Your ref: TR050007
My ref: DCO/TR050007/HinckleySRFI

8th March 2024

**TR050007 Hinckley SRFI – Warwickshire County Council (20040686)
Comments on Documents Requested to be Submitted by Deadline 8**

Project - Originator - Zone - Level - Type - Role - Number      Status      Rev  
**HRF-BWB-GEN-XX-DR-TR-114      S2      P3**

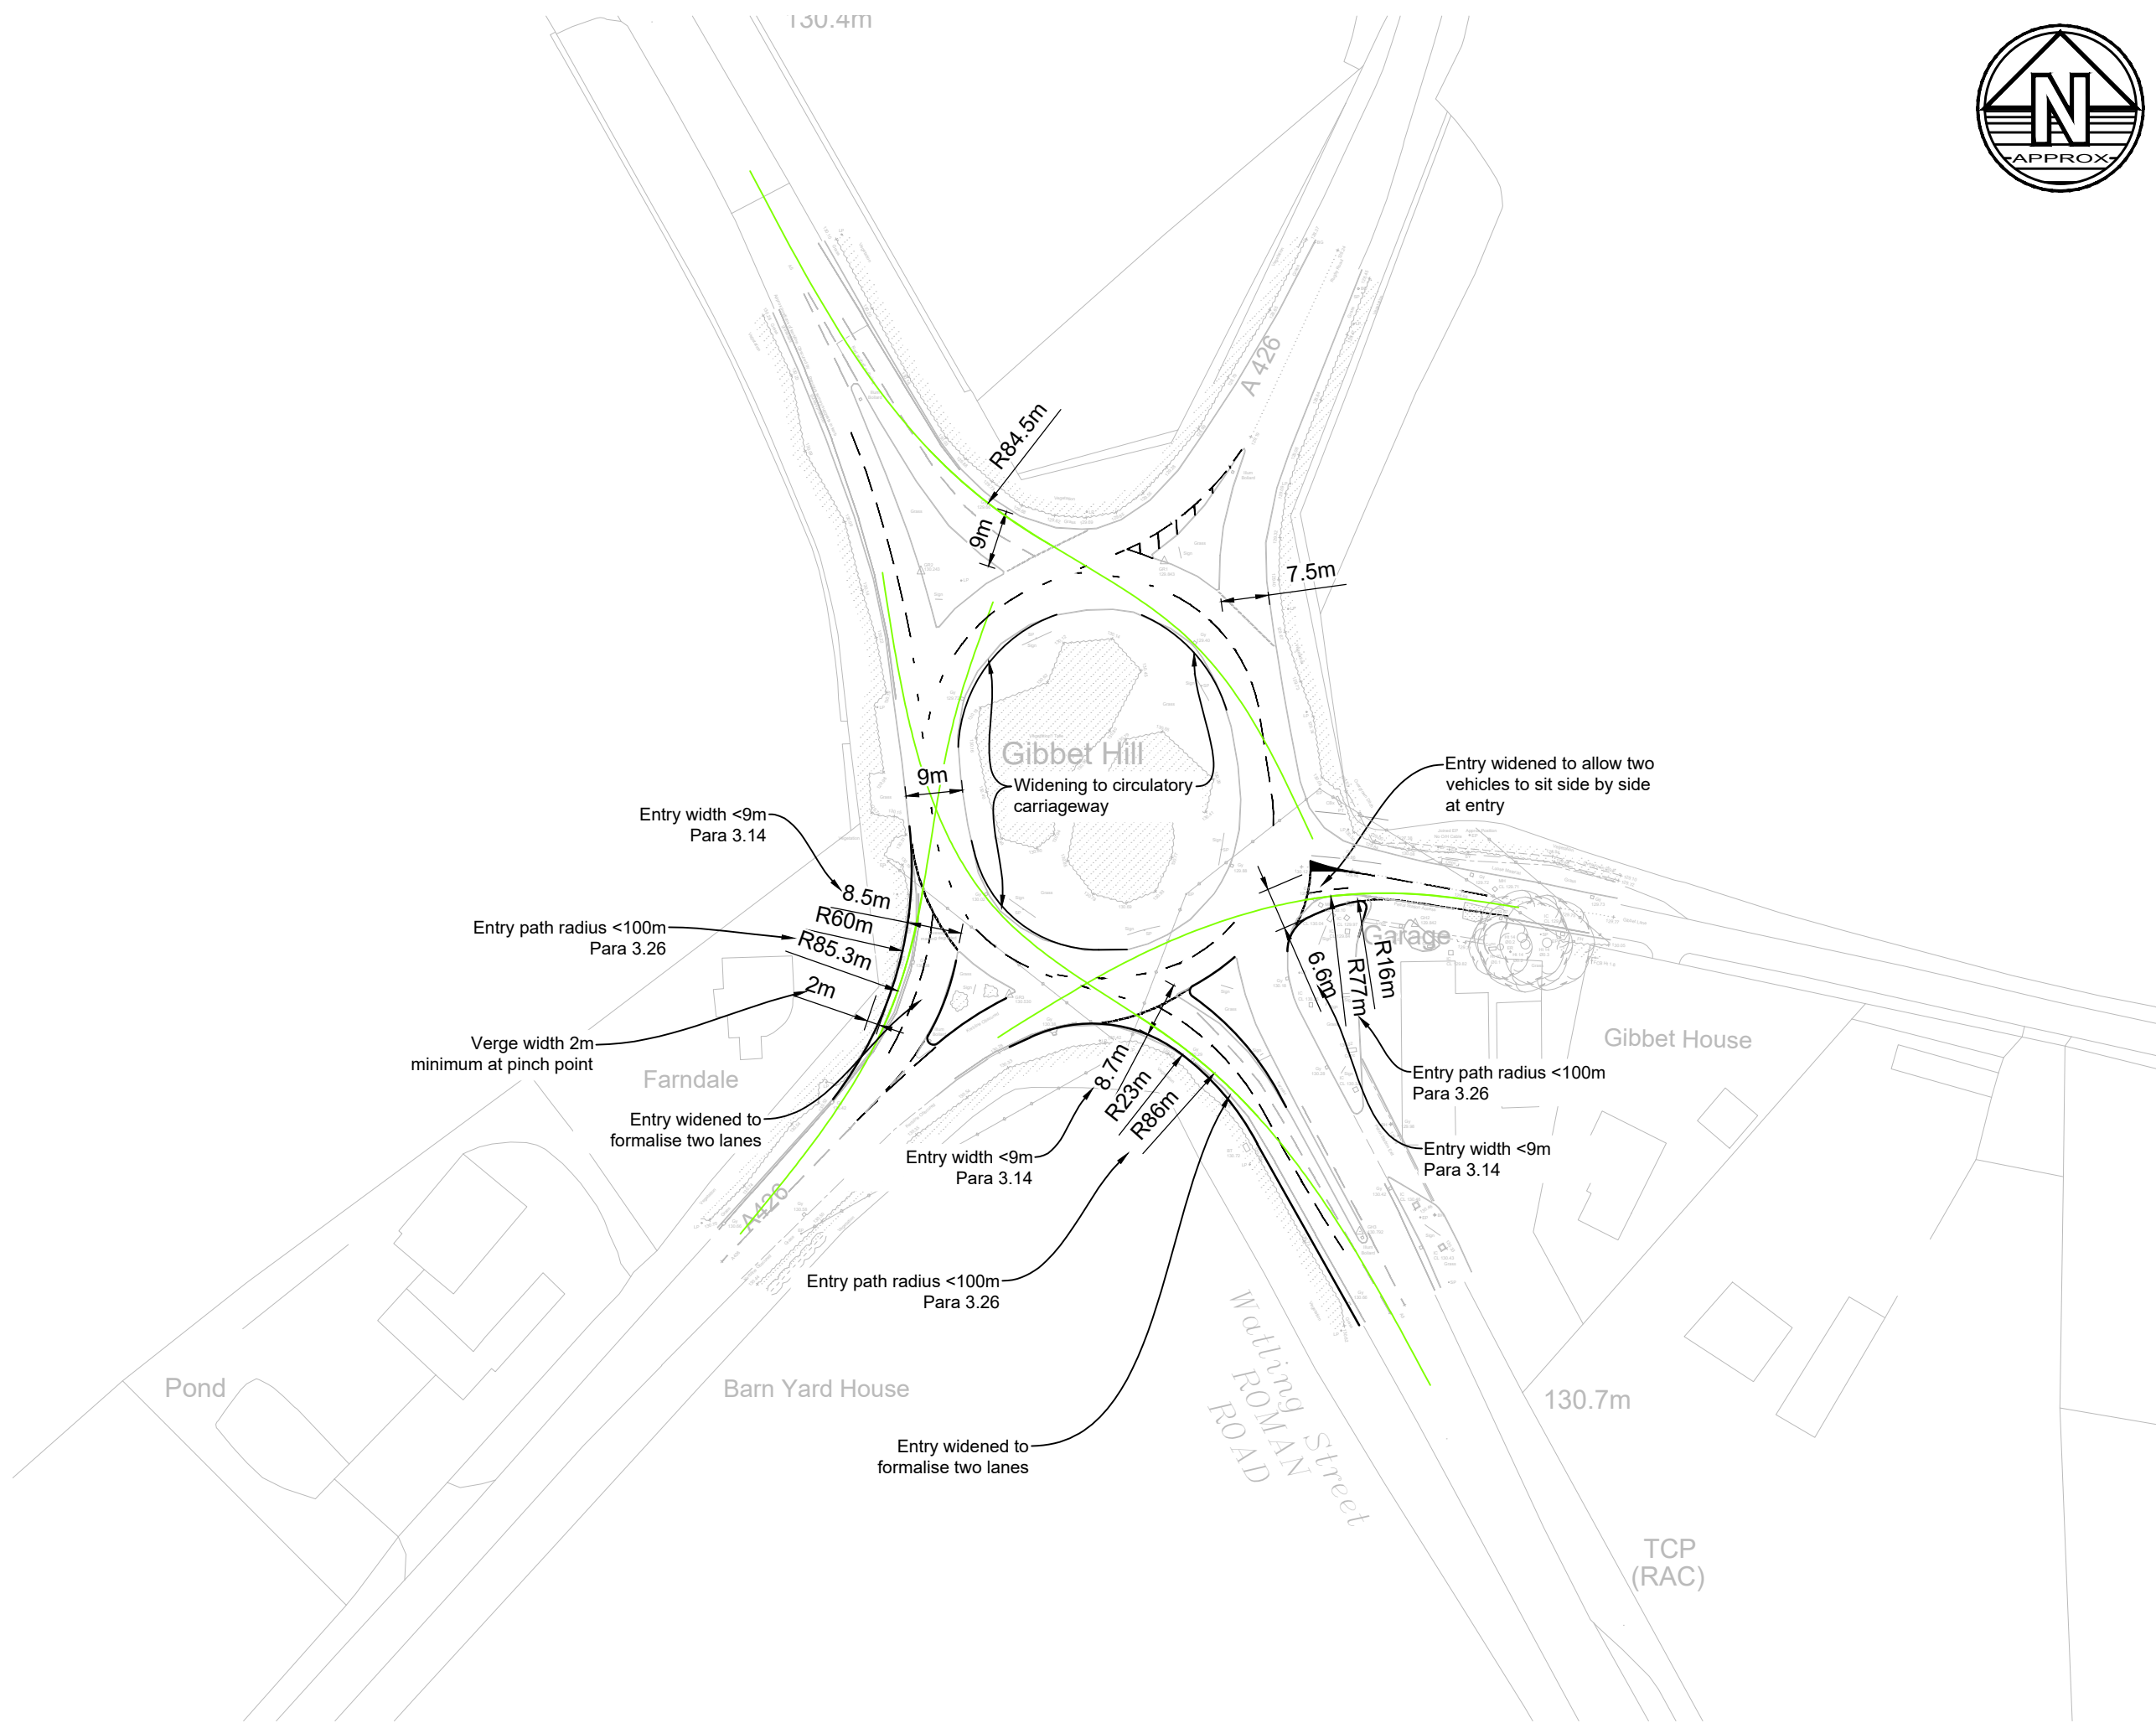
Should the National Highways scheme for Gibbet Hill prove to not be deliverable for some reason, then the fall-back position should be the delivery of an agreed scheme of works shown to mitigate for the impacts of the proposed development. It is understood that the scheme of works proposed has not been agreed with National Highways, and WCC consider that VISSIM modelling should have been undertaken to identify the impact of the additional development traffic, and to model a mitigation scheme, as the ARCADY assessments carried out do not reflect the peak hour queues observed on the A426 Northbound. See further comments below.

The Applicant has submitted updated ARCADY modelling to National Highways for the existing junction layout and a scheme of proposed mitigation to address comments made by National Highways in regard to the need to use the lane simulation tool (HGVs cannot travel in parallel around the circulatory A5 east to west) and include proportions of HVs. This information has been summarised in the form of a Technical Note (Doc Ref 22.2 and we expect it to be submitted by The Applicant at Deadline 8) and we received a copy of the TN and ARCADY models on 5th March. Meetings have been held over the last week to discuss the modelling and the proposed scheme of mitigation, however this has not been agreed with National Highways. The Applicant has provided a cost estimate to National Highways for review (understand this is the amount included in the UU - £344,967.07), the breakdown/Bill of Quantity has not been provided to WCC or LCC, however we did provide information to The Applicant on 7th February to advise that WCC's Engineering Design Service recommend a contingency of between 50% and 60% be applied to any concept stage plans to reflect the level of risk to the delivery authority in respect of increases in construction rates, absence of details around construction specifications and design, absence of statutory undertakers equipment, ground investigations, drainage details, absence of consideration for traffic management/diversions/hours of working and other such unknowns.

The preferred approach would be for a contribution to be made towards the National Highways scheme for improvement at this junction, as their scheme will be designed to accommodate the cumulative impacts of several committed developments. However should the National Highways scheme not progress for any reason, then the fallback should be the provision of the scheme of mitigation that has been agreed as sufficient to mitigate for the development impacts. Therefore the cost estimate used to inform an agreed contribution needs to be as robust as possible to reduce the risk of a scheme not being delivered at all, or the public purse having to bridge any potential funding gap. If the contribution were to be agreed and included within a s106 agreement, there could
